From: Anita Gardner
Sent: 30 June 2017 16:39
To: Planning.Responses
Subject: FW: East St/Fitzalan Rd, Littlehampton - Ref. LU/173/16/PL - Surface Water Drainage
Importance: High

Subject: RE: East St/Fitzalan Rd, Littlehampton - Ref. LU/173/16/PL - Surface Water Drainage
Importance: High

Subject: RE: East St/Fitzalan Rd, Littlehampton - Ref. LU/173/16/PL - Surface Water Drainage

PROJECT	CRL LITTLEHAMPTON 38-40 EAST STREET & 35 FITZALAN ROAD LITTLEHAMPTON, BN17 6AN
DRAWING	DRAINAGE DETAILS Sheet 2 of 3
SCALE	F2505/07
DATE	1:20
DATE	FEB 17
INITIAL	MH
REV	-
CHKD	-

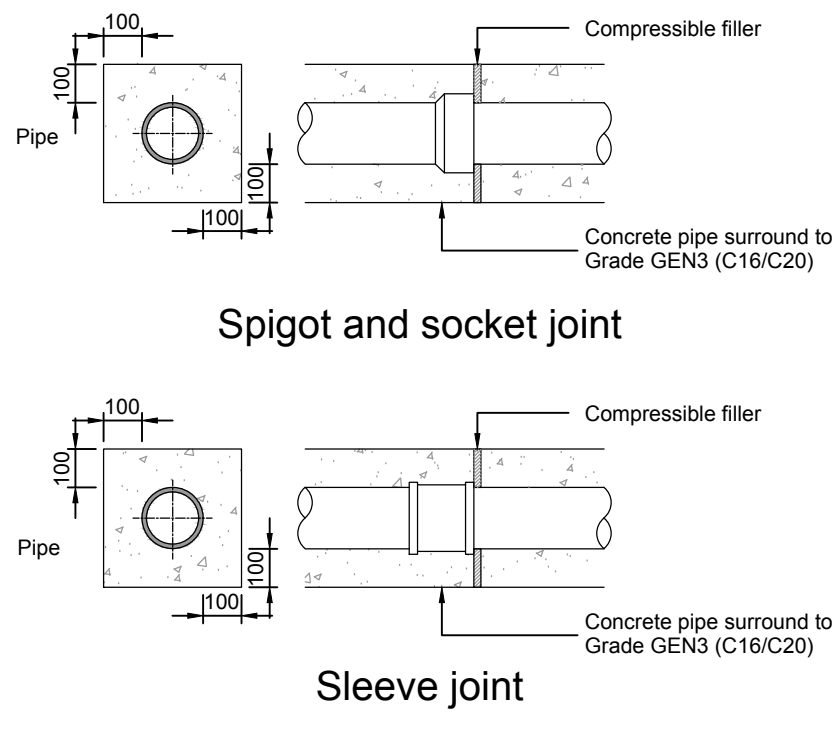
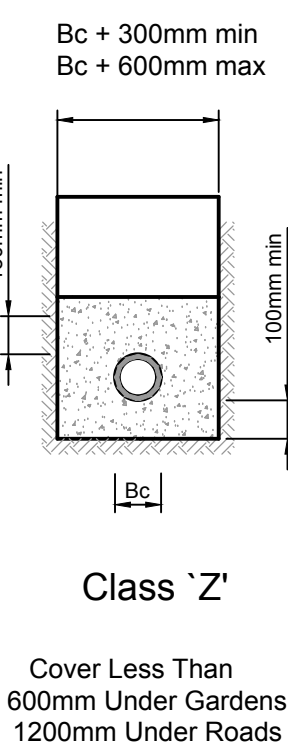
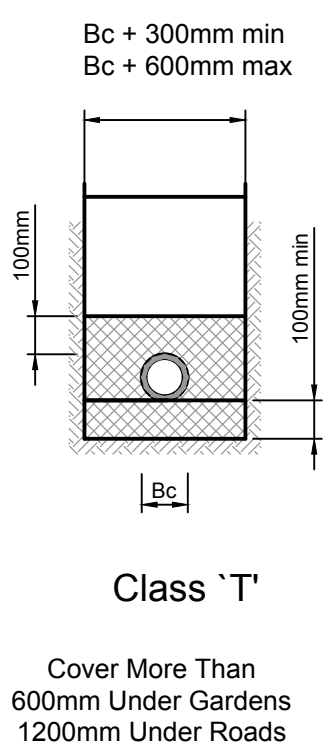
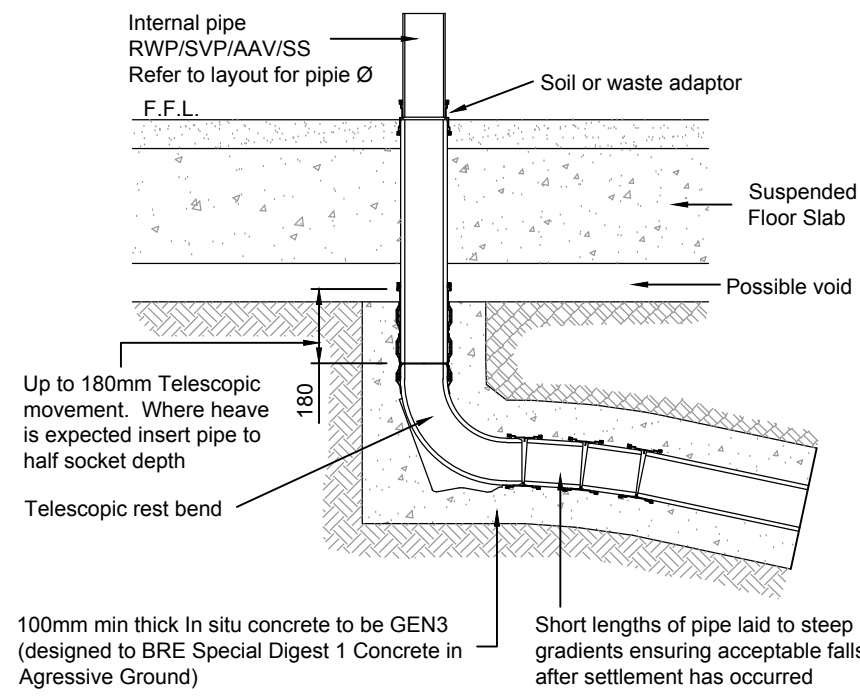
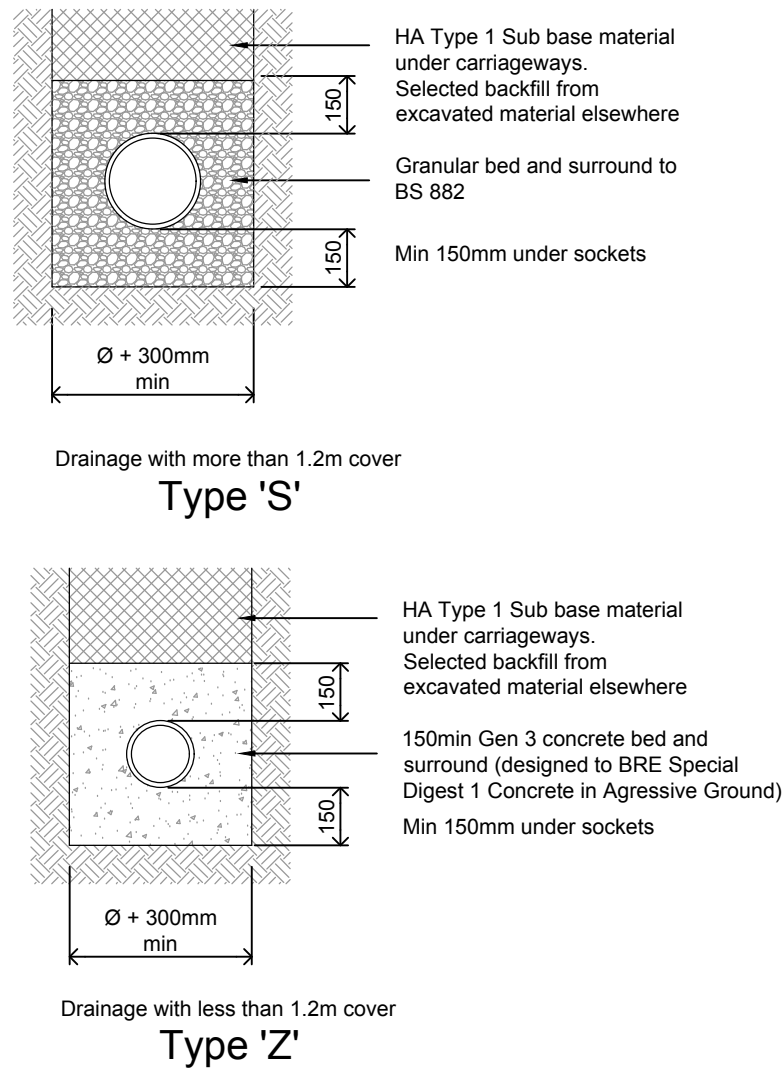
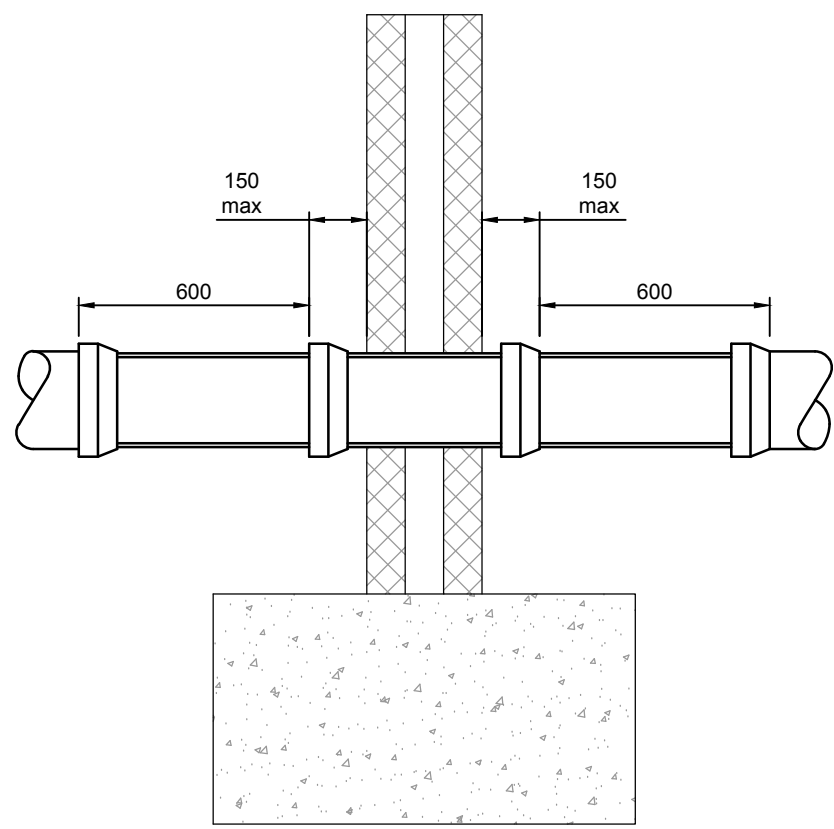
7. An overflow pipe is shown on drg. F2505/08) but not shown on the layout drawing. No invert levels specified. Please clarify.
8. Provide a copy of the manufacturers technical data sheet for the hydrobrake .

- a. Detail shown on 08 is a typical detail. Invert/Pipe levels as shown on layout drawing
 - b. Note added to layout drawing 02F that SW2 - no overflow is provided

FIGURE S-3

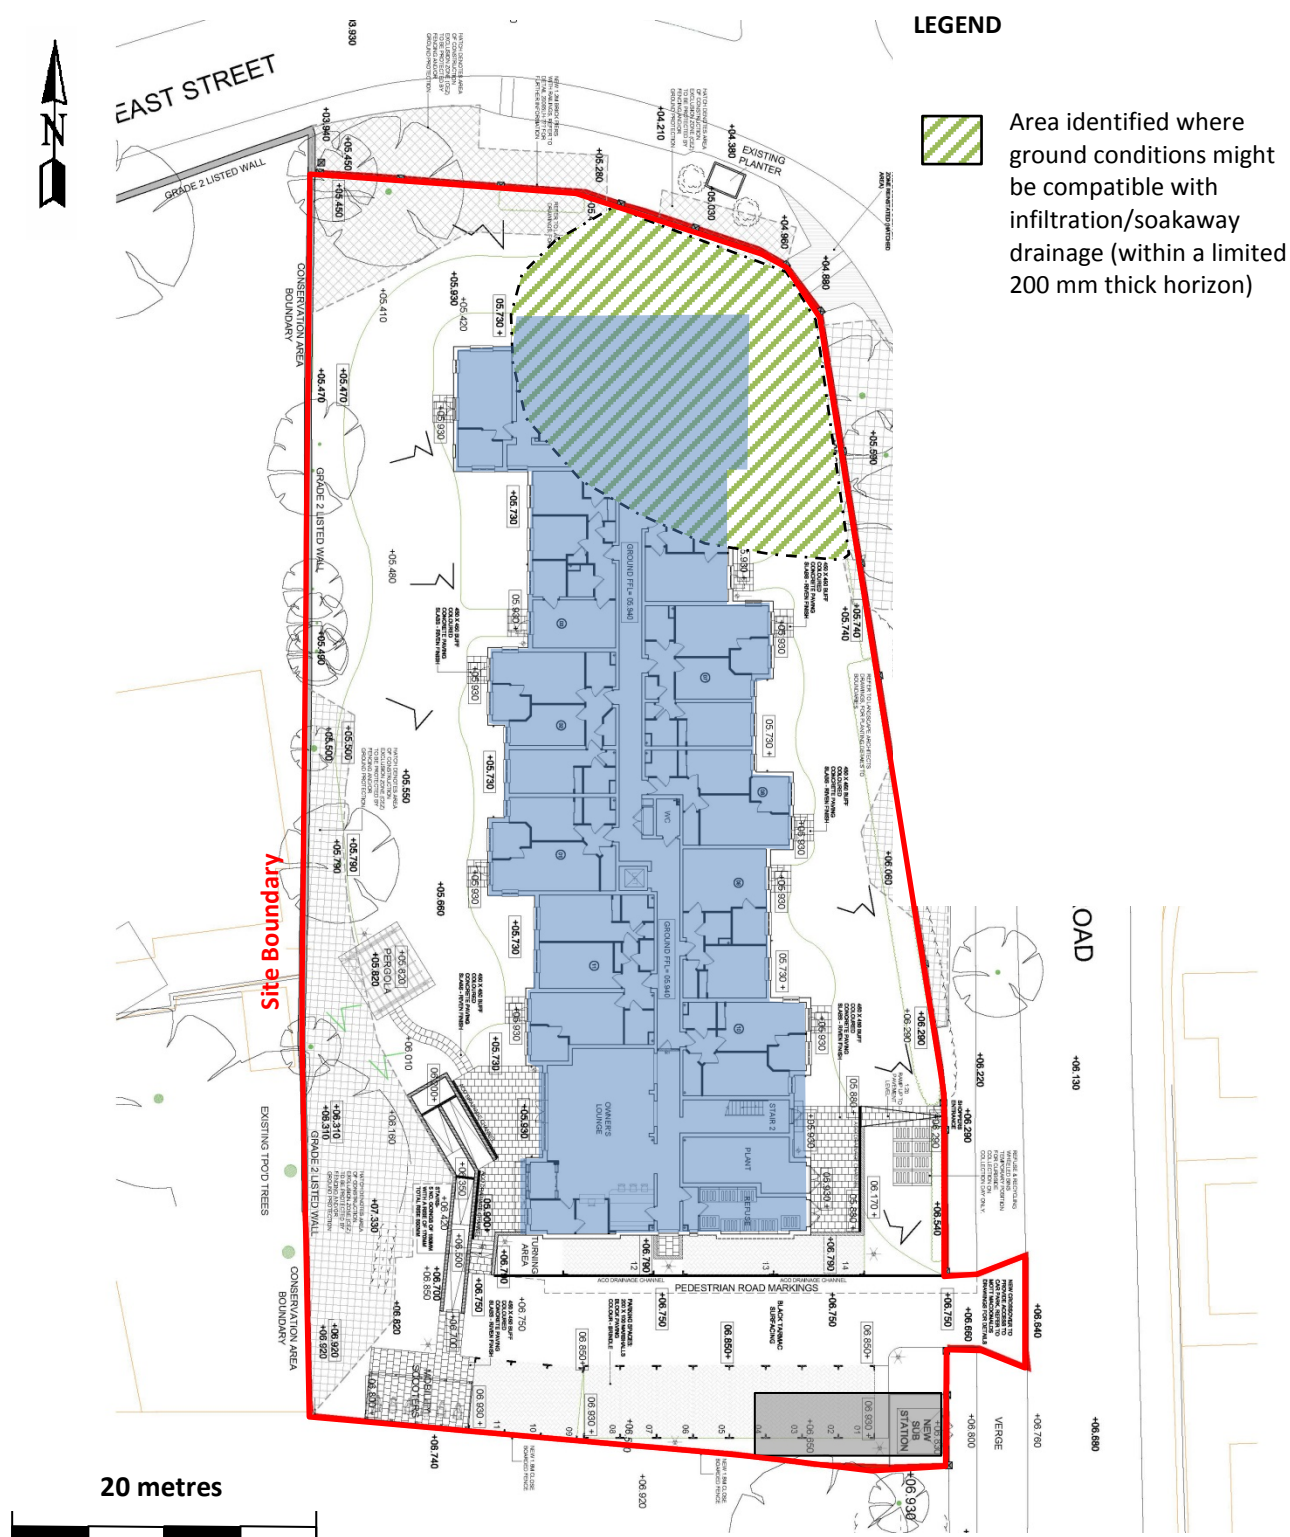
With respect to the 10m exclusion zone, Ciria C574 (clause 7.8.3) refers to 'shallow' foundations and a soakaway distance range of between 5 and 10 metres. Please also note that this particular locality is not a known area of dissolution issues. Known dissolution issues in this district are generally just north of the A27 trunk road.

Bearing in mind the above and noting that piling equipment has been seen on site, please could you provide details of the proposed foundations and explain why a 5m distance cannot be applied in this instance. Please also revise your drawing to identify available areas for soakage based upon the 5m distance. The crane platform is temporary, so should not be included as part of the exclusion zone, except where other exclusion zones overlap it.

In view of the recorded ground conditions, as above, it is evident that water percolation into chalk strata can only be relied upon over a limited depth range (200 mm), namely between 1.8 m and 2 m depth (to maintain 1 m unsaturated zone below the base of soakaways and the characteristic groundwater level). Such a limited infiltration zone would severely constrain soakway design.

As shown in our Figure S-3, only a very limited area of the site is provided where chalk strata are present above the characteristic groundwater level and where the 200 mm thick infiltration zone is provided. Such a limited volume of suitable strata is considered not to provide a reliable soakaway solution over the design life of the proposed development.

It is noted that most of this area lies directly below the proposed building and within the designated tree protection zones; none of this area of suitable strata is more than 5 m from the proposed building foundations.

As apparent from the above issues relating to ground conditions (and with reference to Figure S-3), the use of soakaways is effectively precluded.
